**Dogger Bank South Offshore
Wind Farms**

**Response to Rule 6 Letter
Pre-Examination Procedural Deadline**

Document Date: October 2024

Dogger Bank South Offshore Wind Farms Project
Pre-Examination Procedural Deadline Cover Letter and Response to Rule 6 Letter
PINS Reference: EN010125

Figure: 23-2	Drawing No: PC2340_LUC_ON_ZZ_DR_Z_23_2	
Co-ordinate system: British National Grid	Page Size: A3	Scale: 1:45,000
Project: Dogger Bank South Offshore Wind Farms	Report: Dogger Bank South: Environmental Statement

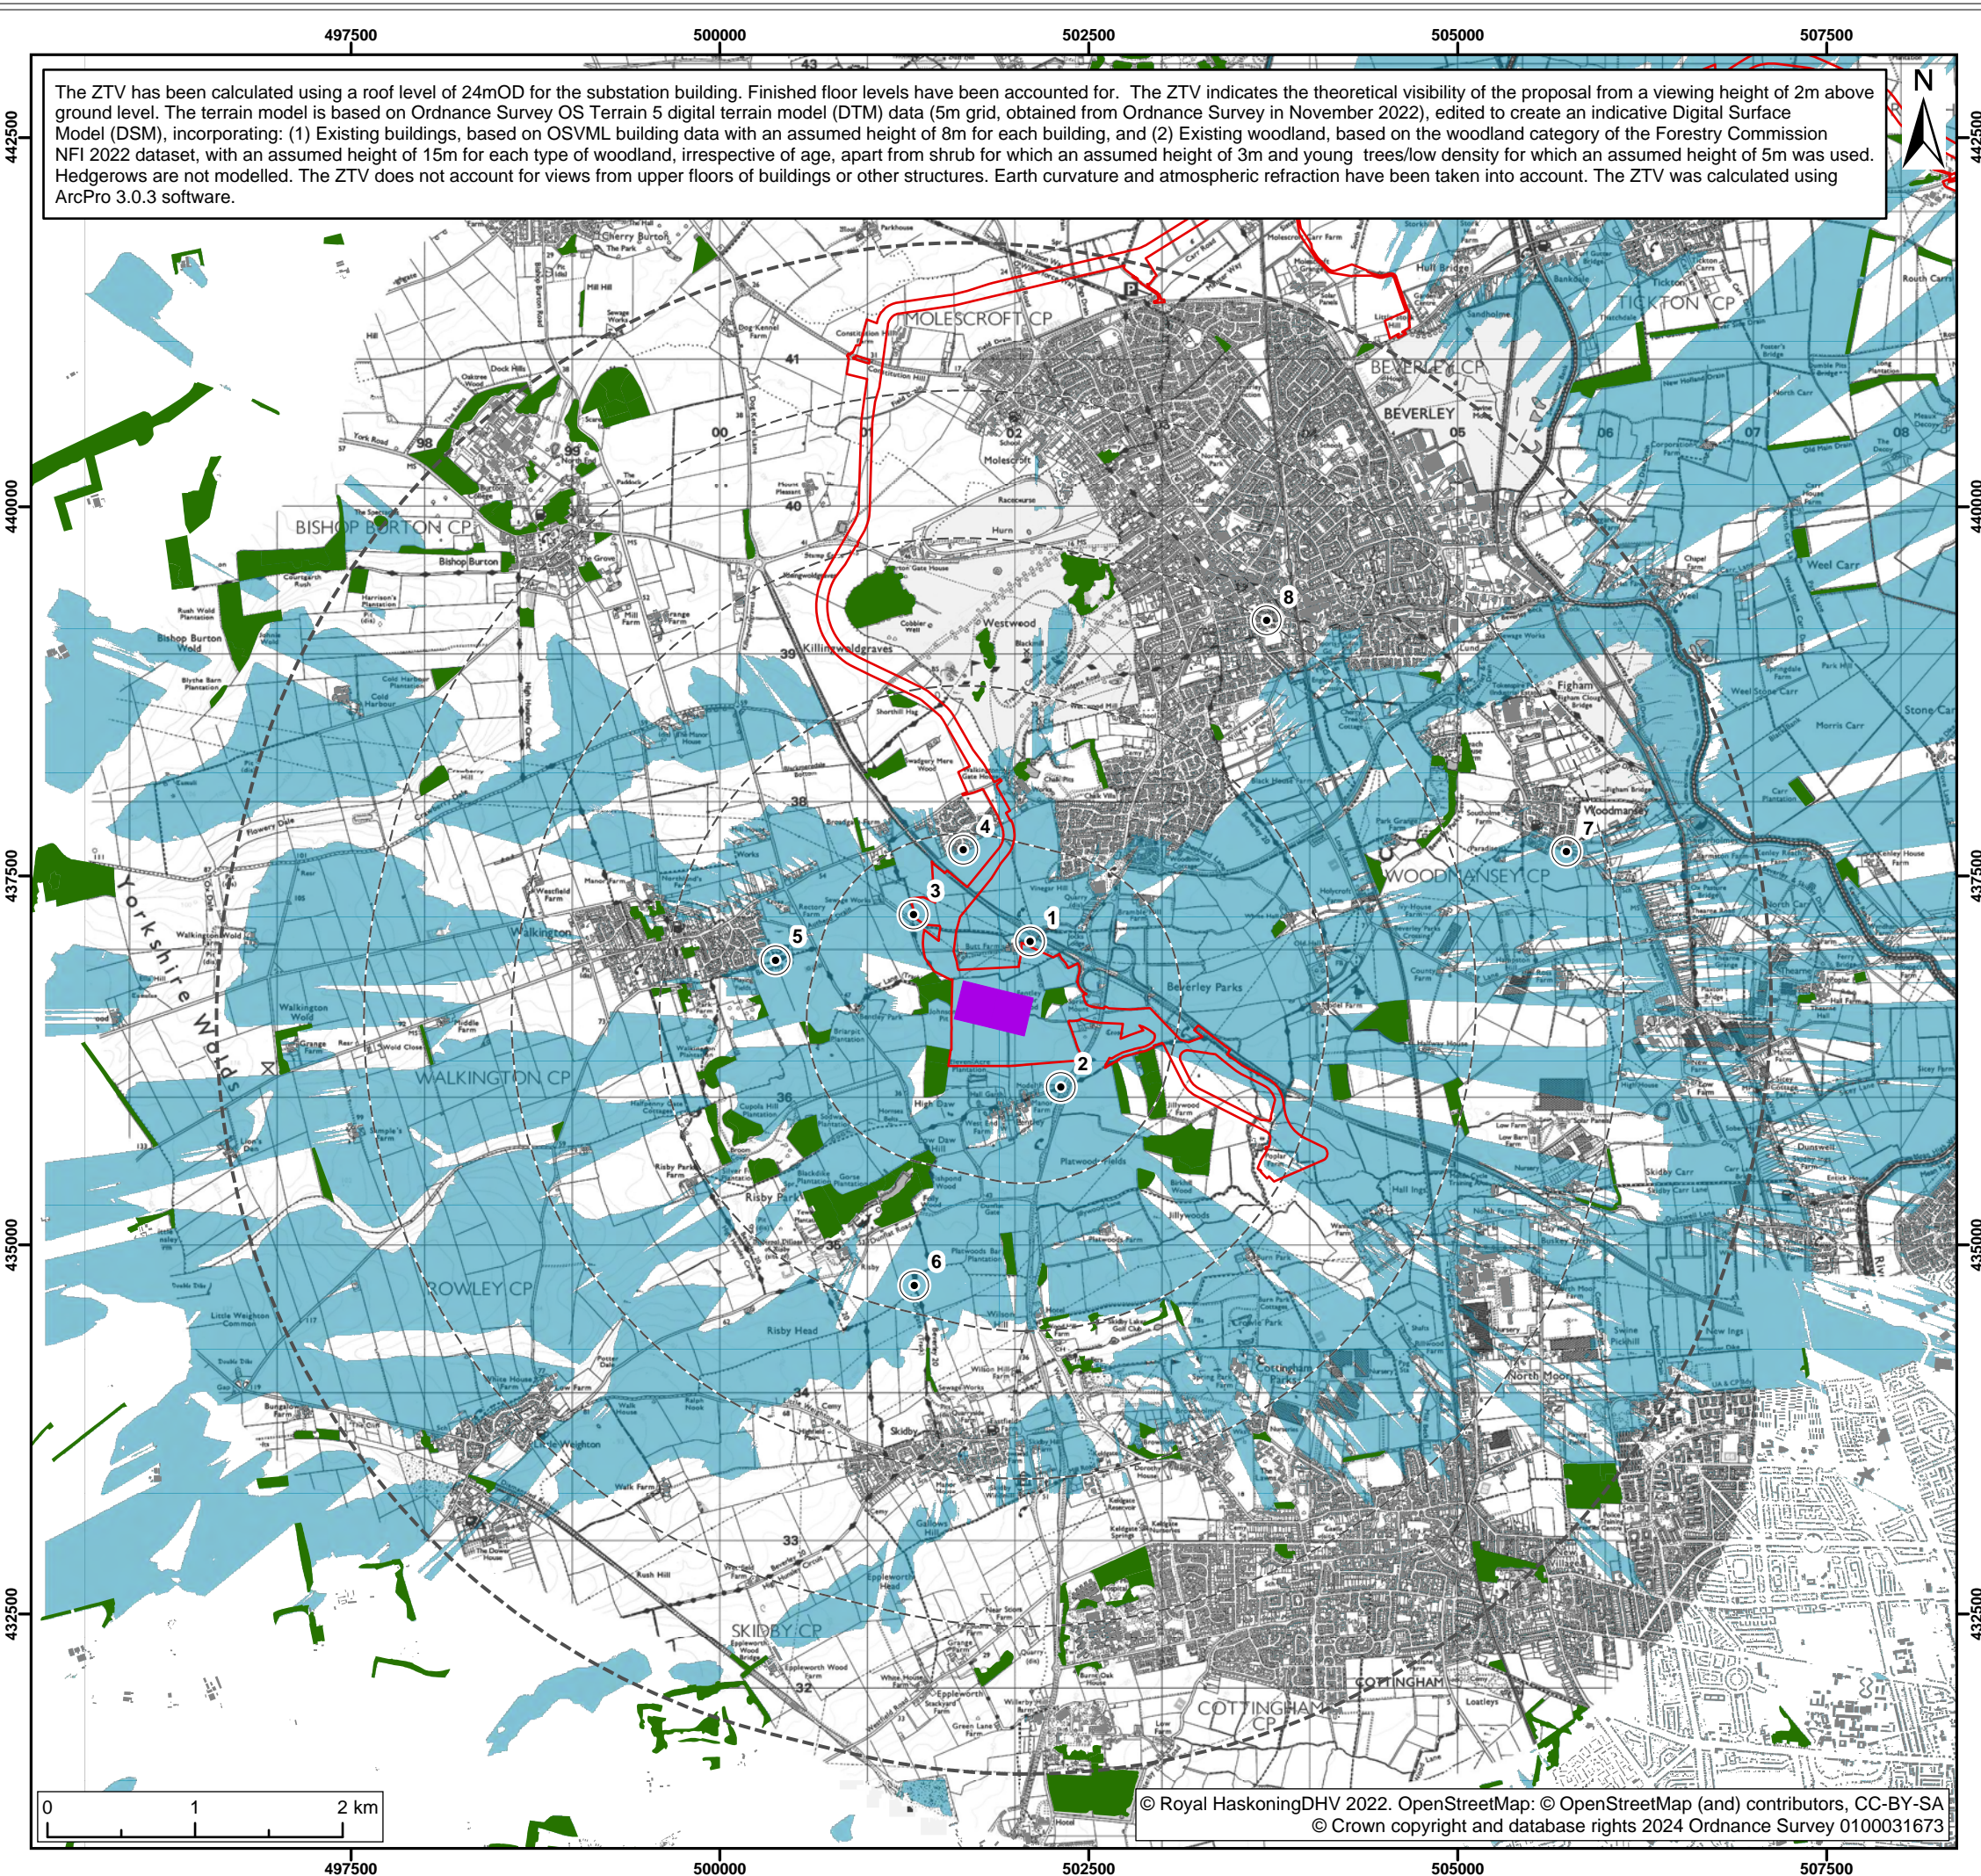
ExA's request/comment	Applicants' response
	Statement, appended to the report are incorporated into the detailed design and secured through Requirements 10, 11 and 12 and in the draft DCO [APP-027].
Request for additional plans	
To help the ExA with its consideration of the Application please provide the following additional plans:	
<p>A topographical* map for the convertor station zone of theoretical viability</p> <p>*Assumed error for 'topographical'</p>	<p>Figure 23-2b has been prepared to show the topography data in relation to the Landscape and Visual Impact Assessment study Area and viewpoint locations and has been provided as part of the Pre-Examination Procedural Deadline submission within an update to the Chapter 23 - Landscape and Visual Impact Assessment - Figure 23-1 to Figure 23-15 [APP-193].</p> <p>It was not possible to clearly show the topographical data by adding it to Figure 23-2a - Onshore Substation Zone of Theoretical Visibility.</p>
